# BCA 2022 AMENDMENT 2 CAPABILITY REPORT FOR SSDA SUBMISSION

<b>CLIENT:</b>	TQM
<b>PROJECT NAME:</b>	LOTUS, HURSTVILLE MIXED USE DEVELOPMENT
<b>PROJECT ADDRESS:</b>	105 FOREST ROAD & 1A HILL ST, HURSTVILLE NSW 2220
<b>DATE:</b>	10 SEPTEMBER 2025
<b>PROJECT NO:</b>	250343

BASEMENT 1 CARPARK

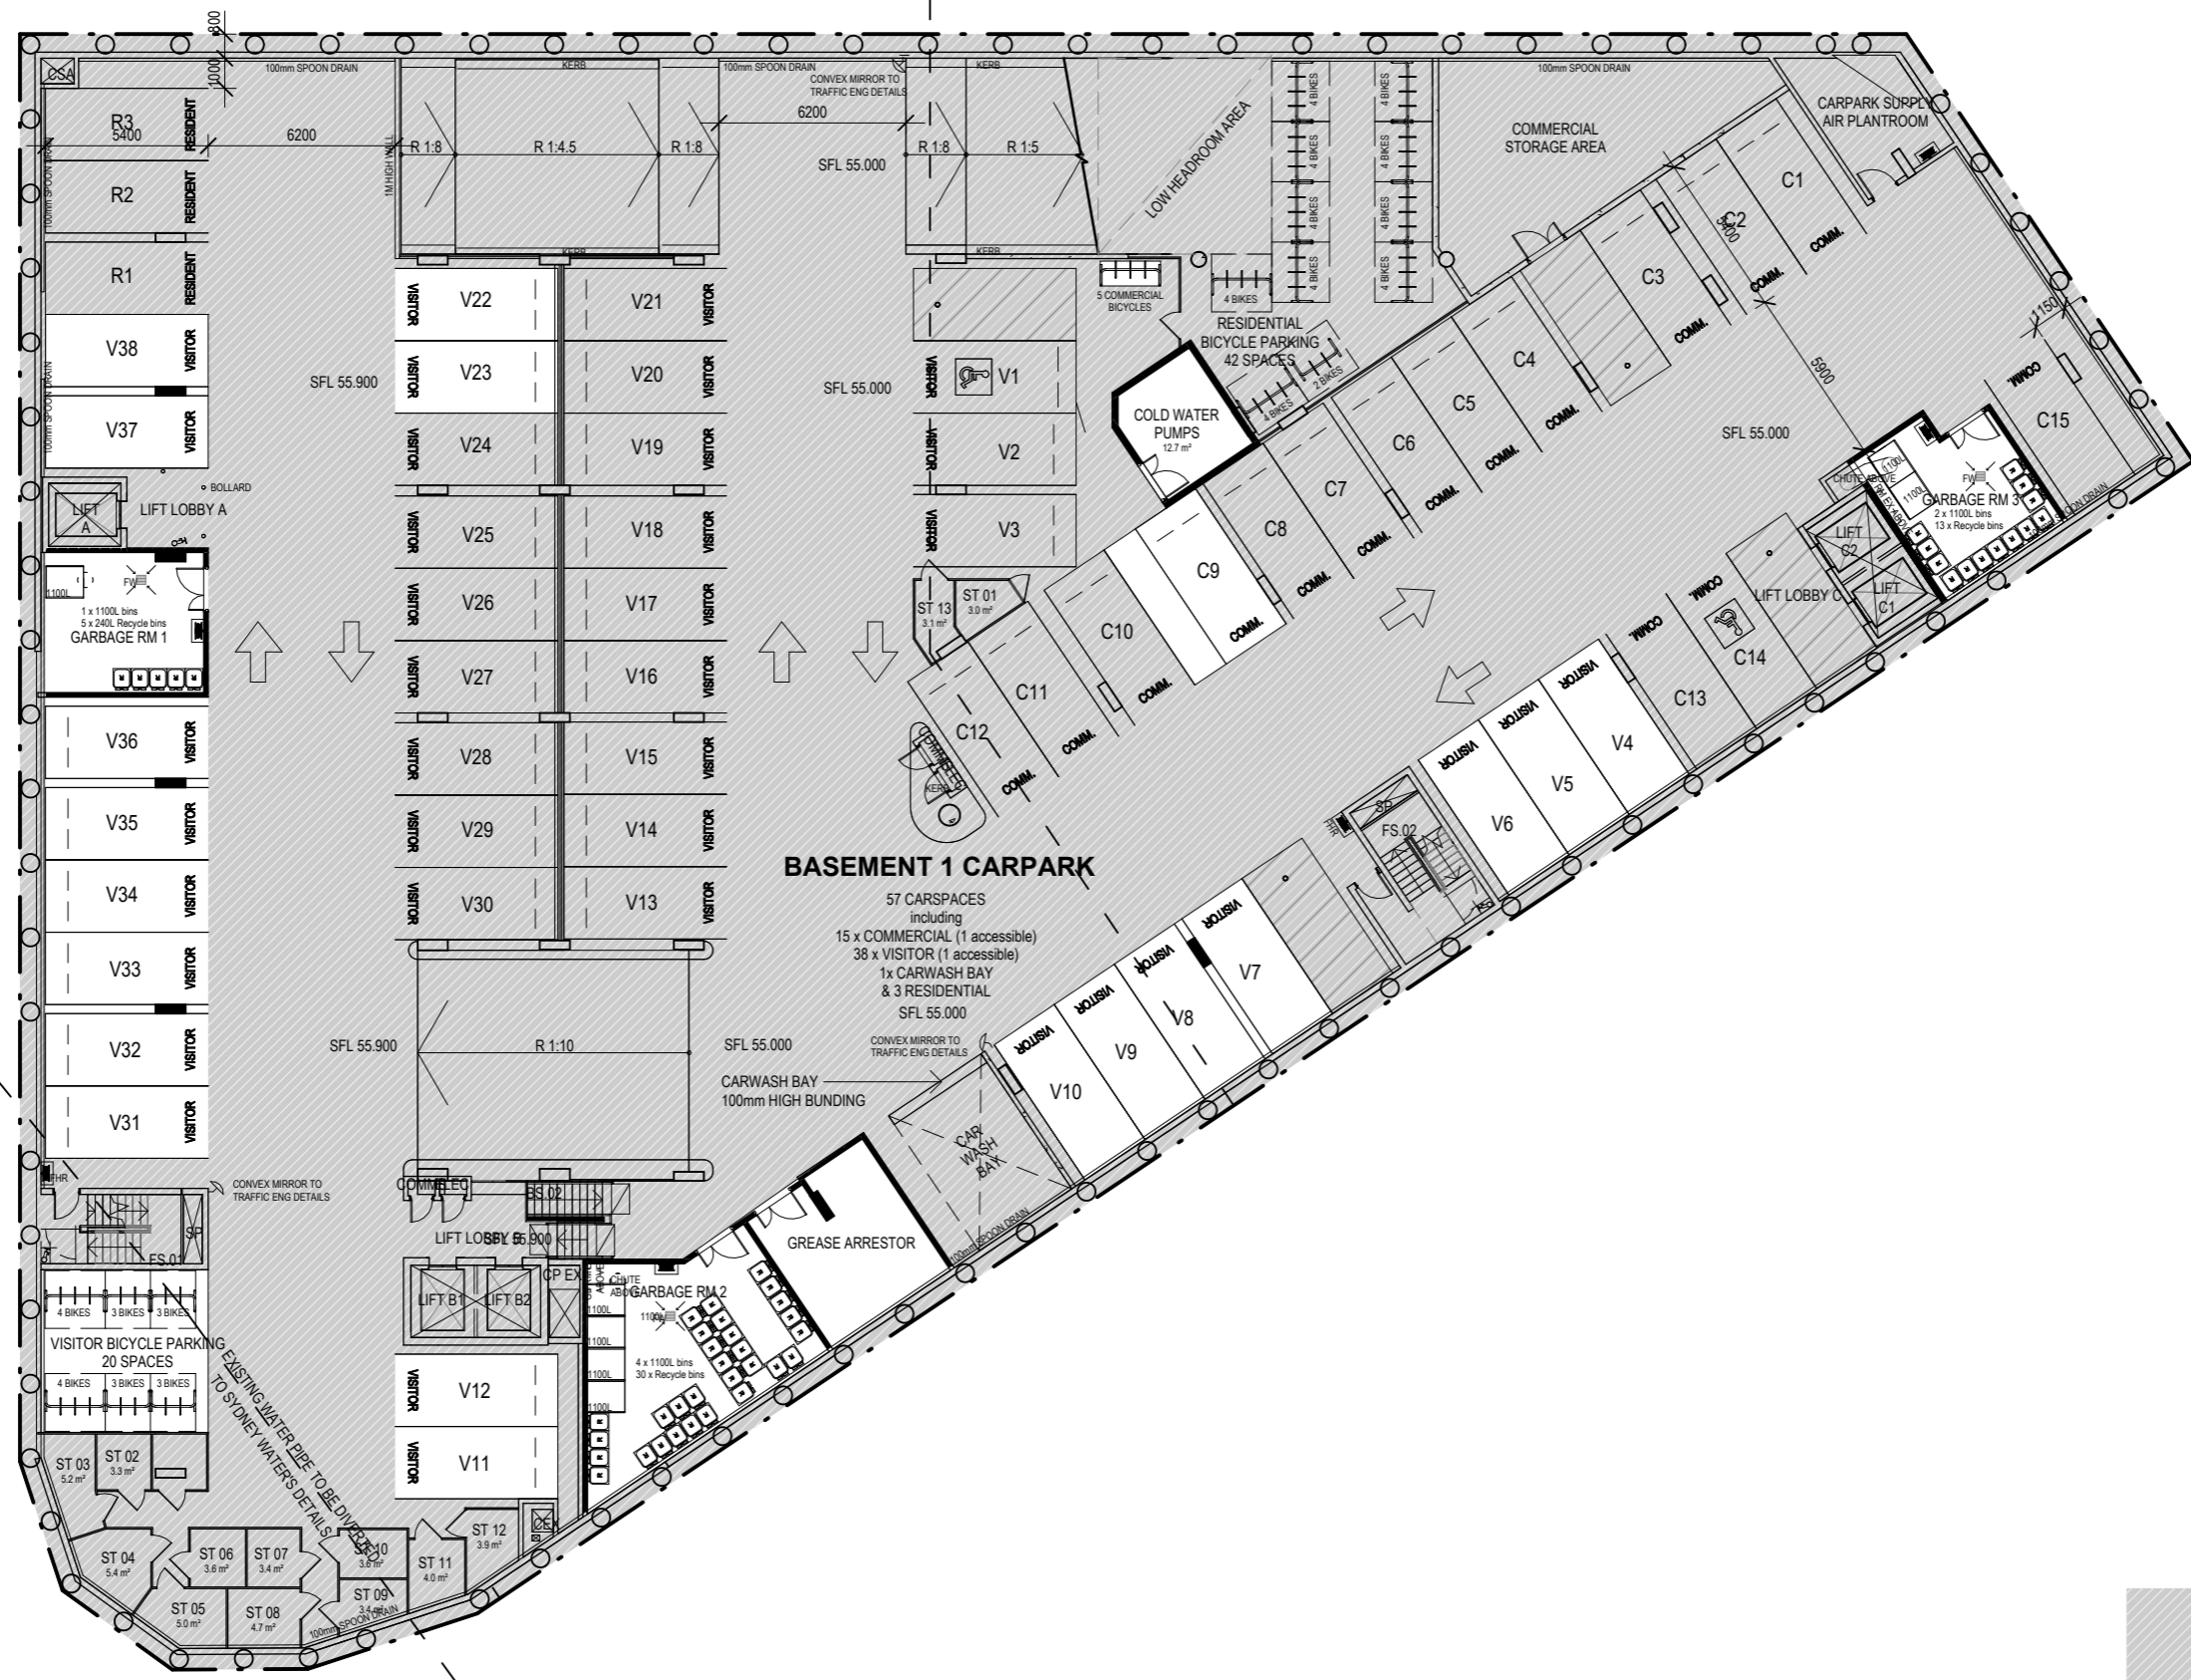
**Basement Level 1:**

A 1000mm unobstructed width is required along the path of travel to an exit. 600mm and 750mm widths are identified on the plans.

**Basement Level 1** - Provide the use and the minimum headroom height in the area denoted as 'Low headroom area'. The head heights of this area are to comply with the requirements of this clause.

**Basement Level 1:**

- a) Extended travel distance of up to 41m in lieu of 20m to a point of choice.

b) Extended travel distance of up to 48m in lieu of 40m to an exit.

GROUND FLOOR

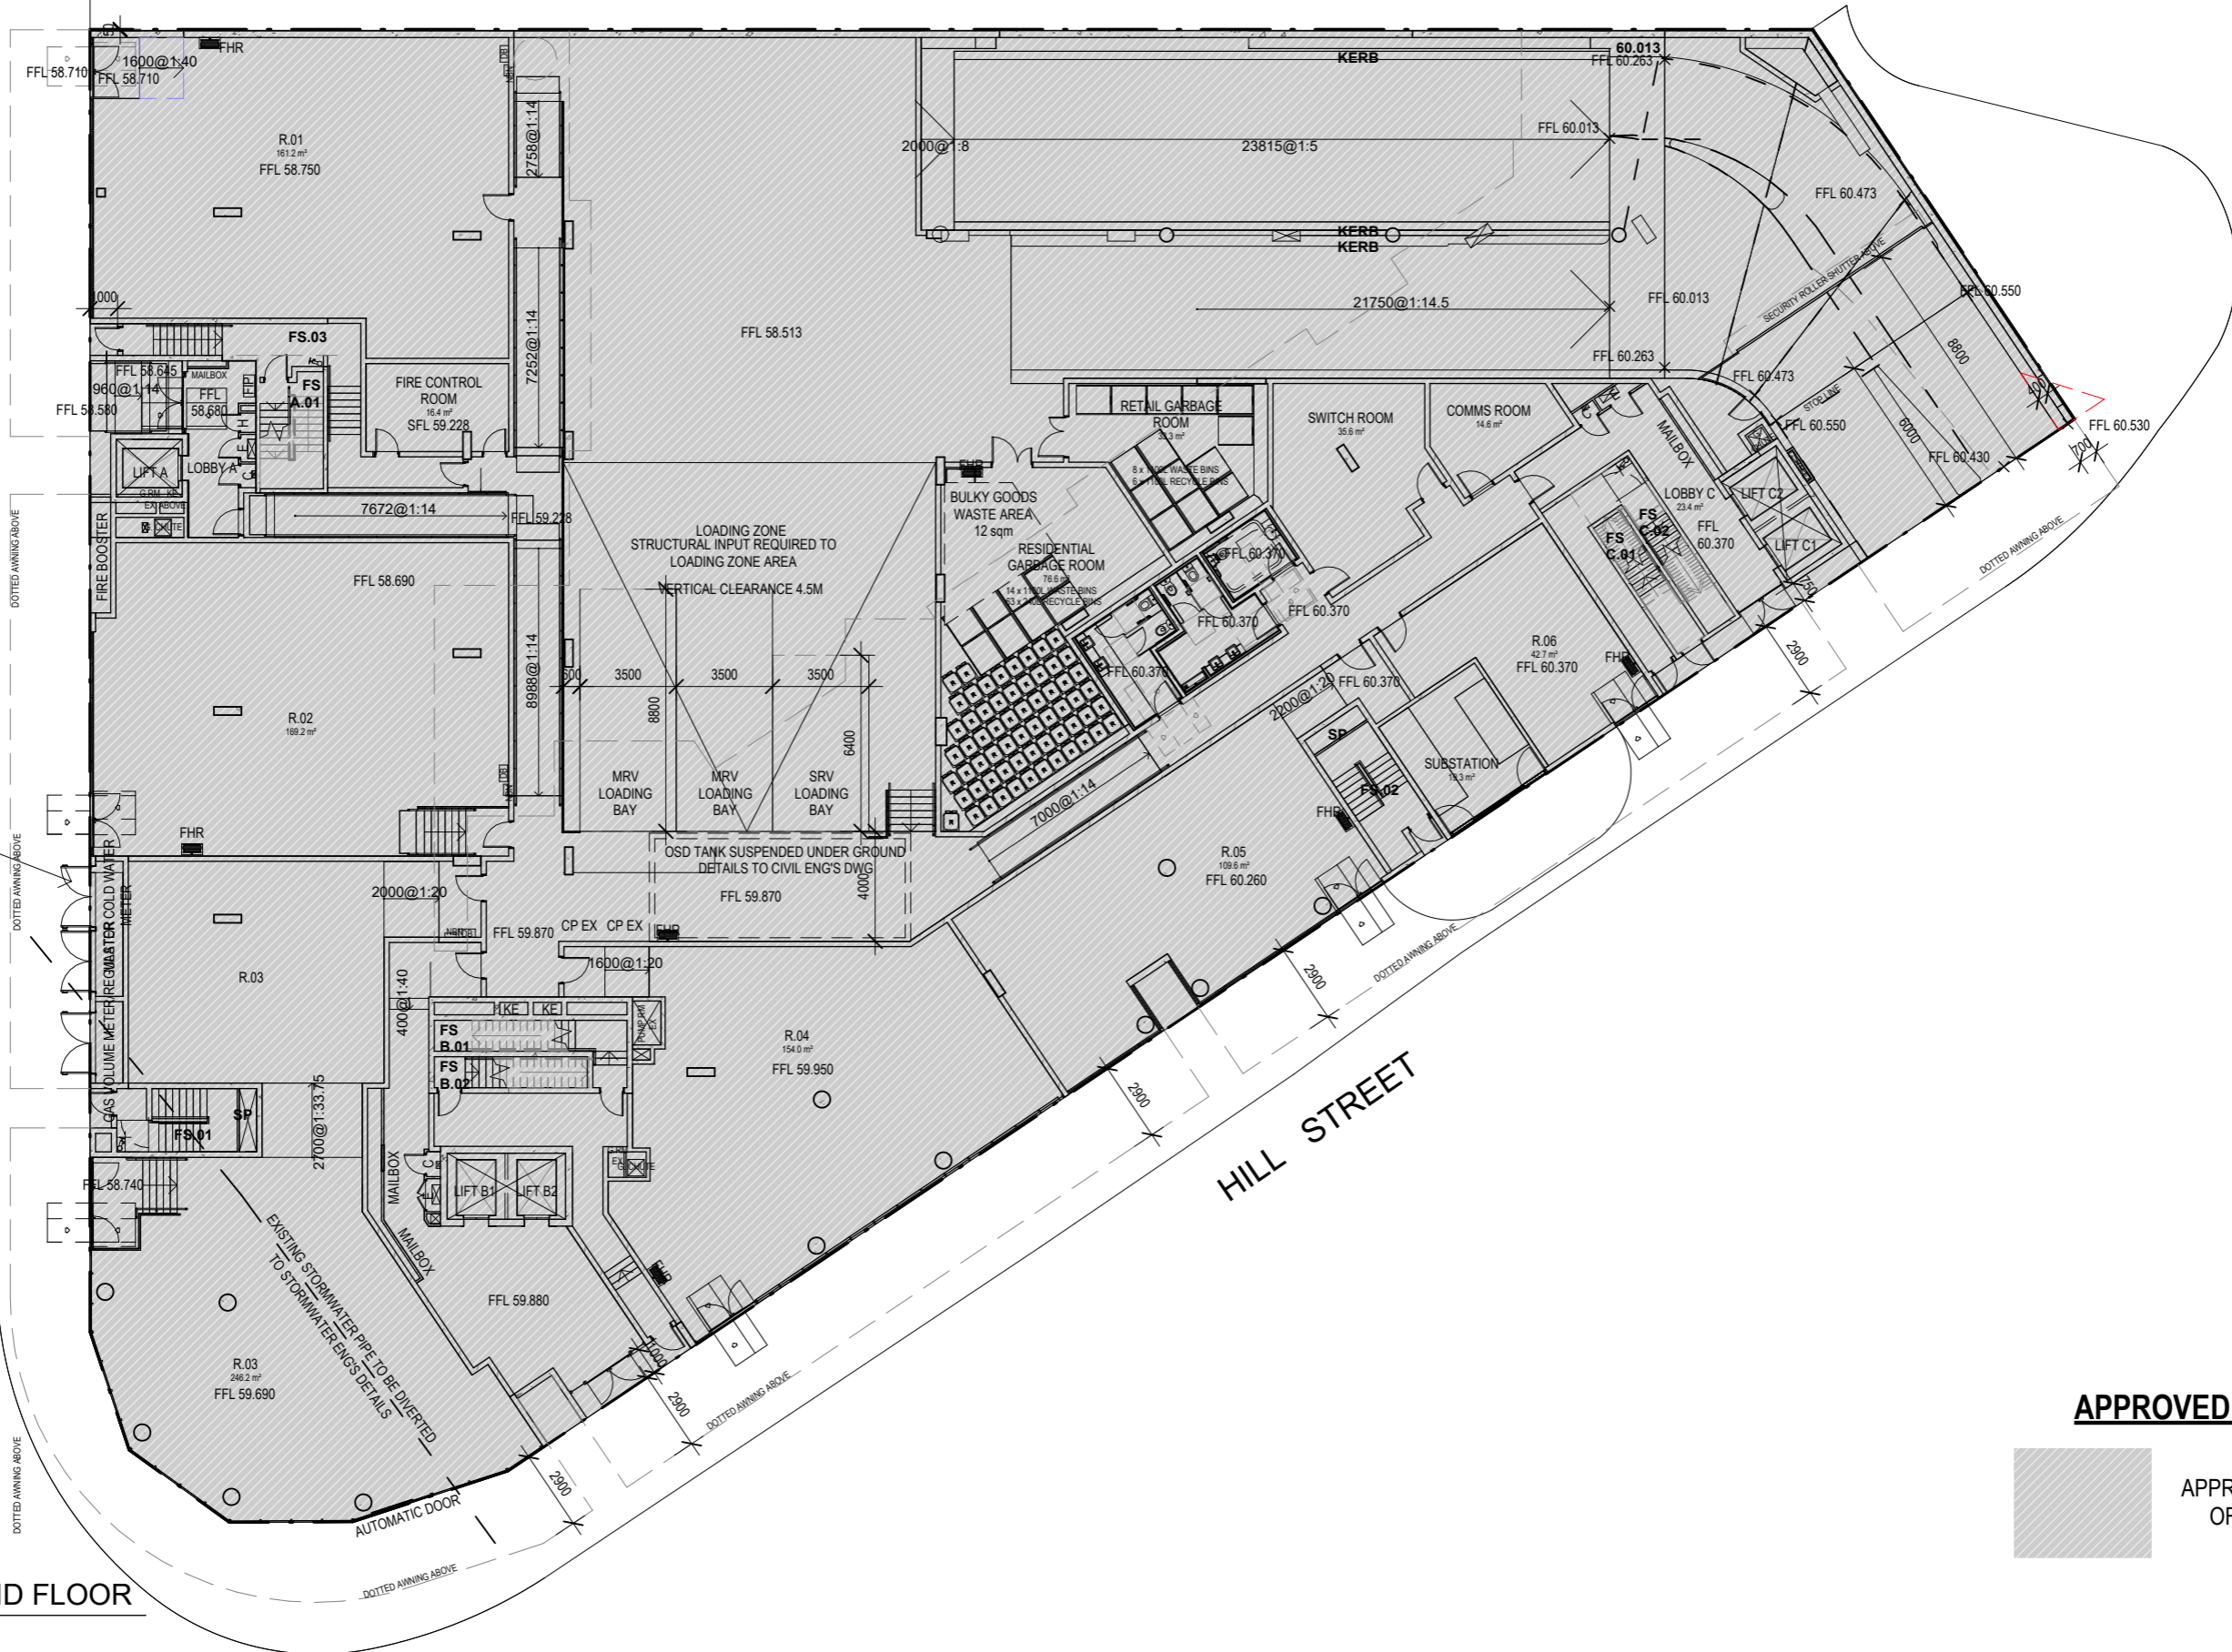
Ground Floor Level: The walls adjacent to the discharge points of the fire-isolated stairs (FS.02 and FS.03) are to have an FRL of not less than 60/60/60.

<p>11.</p>	<p>D3D25</p>	<p><u>Ground Floor Level – Retail tenancy R03:</u> A swinging door in a required exit must swing in the direction of egress if the floor area in that part of the building is more than 200m<sup>2</sup> in accordance with the requirements of this clause.</p> <p>The egress doors for retail tenancy R03, which has a floor area of 246.2m<sup>2</sup> (exceeding 200m<sup>2</sup>), do not swing in the direction of egress, contrary to the requirements of this clause.</p>	<p>Updated plans demonstrating compliance are to be provided or, alternatively, a performance solution will be required to address this non-compliance.</p>
<p>12.</p>	<p>D3D29</p>	<p>Residential levels: The following is required:</p> <ol style="list-style-type: none"> <li>A window opening must be provided with protection, if the floor below the window is 2 m or more above the surface beneath in the class 2 parts of the building.</li> </ol>	<p>The architect is to confirm compliance with the requirements of this clause.</p>

14.	E1D15 Specification 19	<p><u>Ground Floor Level – Fire Control Room:</u> The following is required to be provided on the plans:</p> <p>a) S19C7 – The fire control room is to have enclosing construction of concrete, masonry or the like, sufficiently impact resistant to withstand the impact of any likely falling debris, and with an FRL of not less than 120/120/120.</p> <p>b) S19C8 – the fire control room door openings must be fitted with a self-closing –/120/30 smoke sealed fire door.</p>	<p>The architect is to confirm compliance with the requirements of this clause.</p> <p>It is in the opinion of this office that compliance with the requirements of this clause can be achieved.</p>
